PLANNING CONSULTATION RESPONSE

Application No	2026/0092
Proposal	Change of use of the upper floors of the existing building from Class E to create 2x residential units (Use Class C3) with associated works including erection of external staircase to rear; installation of windows/door, and formation of car parking; and alterations to the existing ground floor commercial frontage.
Address	Andy Longden Studio, 26 - 28 Racecommon Road, Barnsley, S70 1BH
Date of Consultation Reply	09/02/2026
Consultee	Katie Lawrence, Planning Ecologist

6 Rear Elevation
1:50

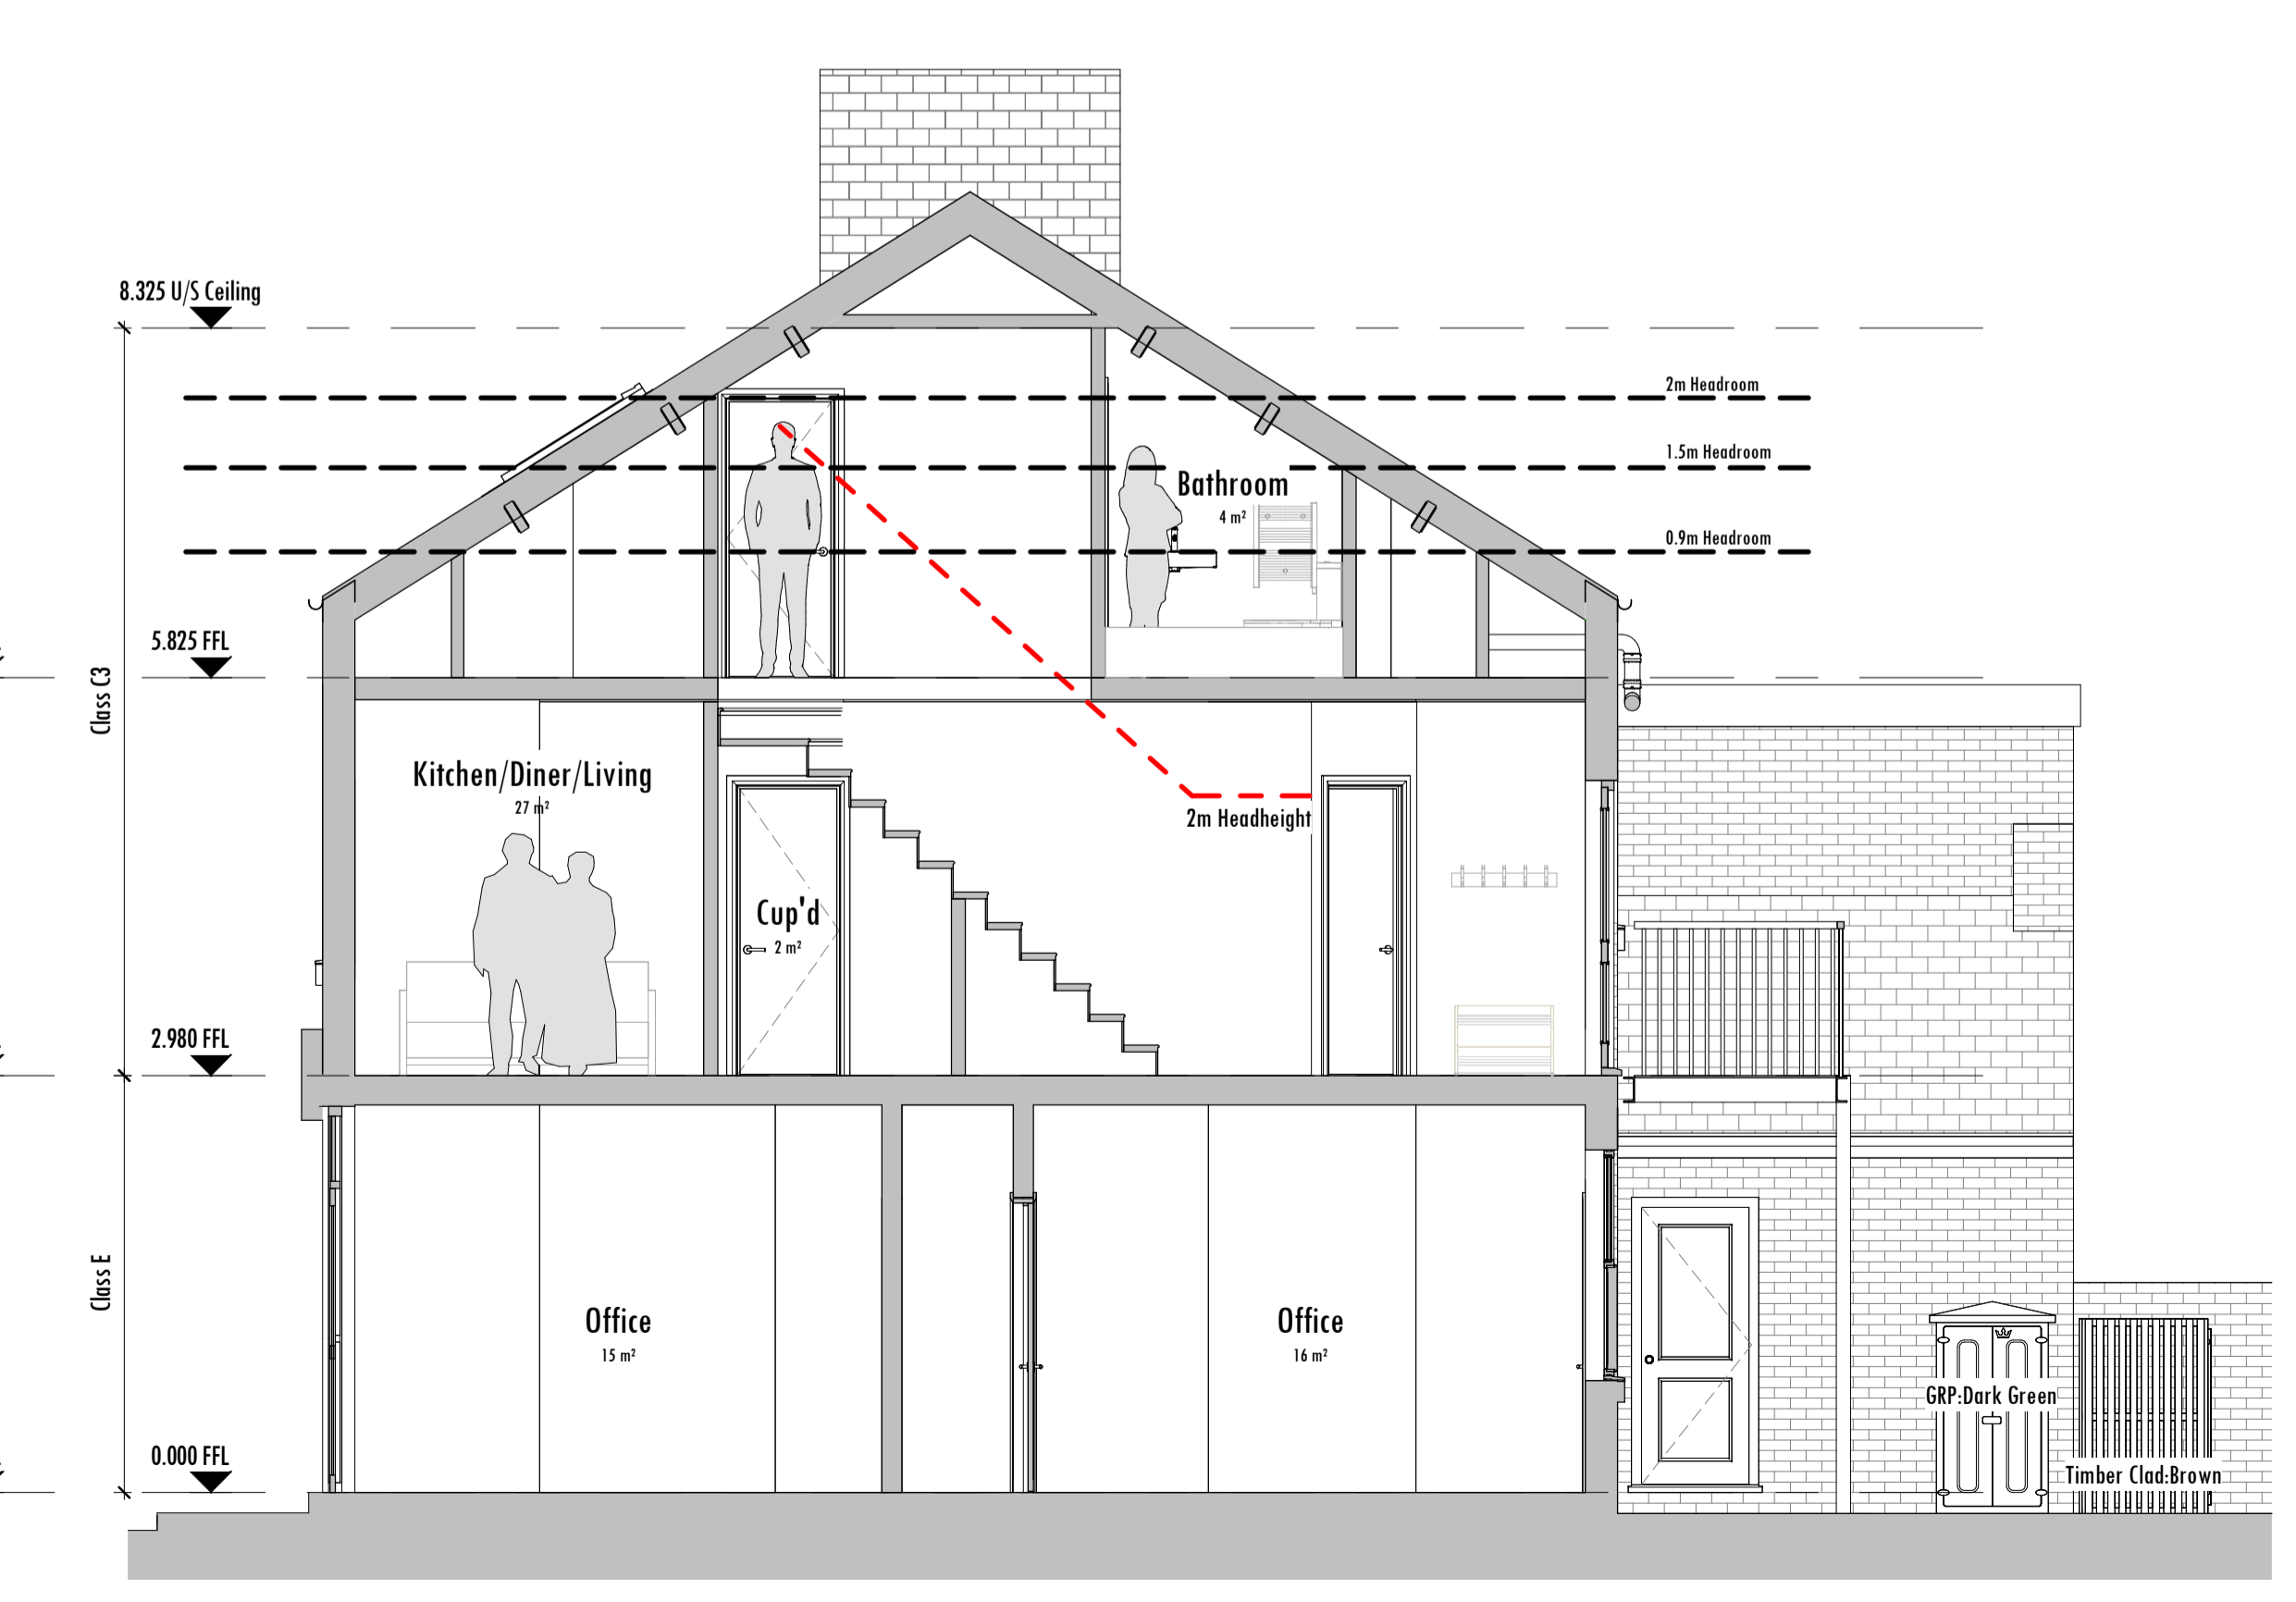
- The applicant has claimed the de minimis exemption from the Biodiversity Gain Condition. This appears to be acceptable with the site comprising areas of building and hardstanding.
- Works to the existing building appear to be largely internal and there is unlikely to be any impact upon bats; however, could the applicant please provide photographs of the outbuilding proposed for demolition as part of the works and also the underdrawings of the loft spaces where bathrooms are proposed to allow me to consider if a bat roost assessment should support the planning application.
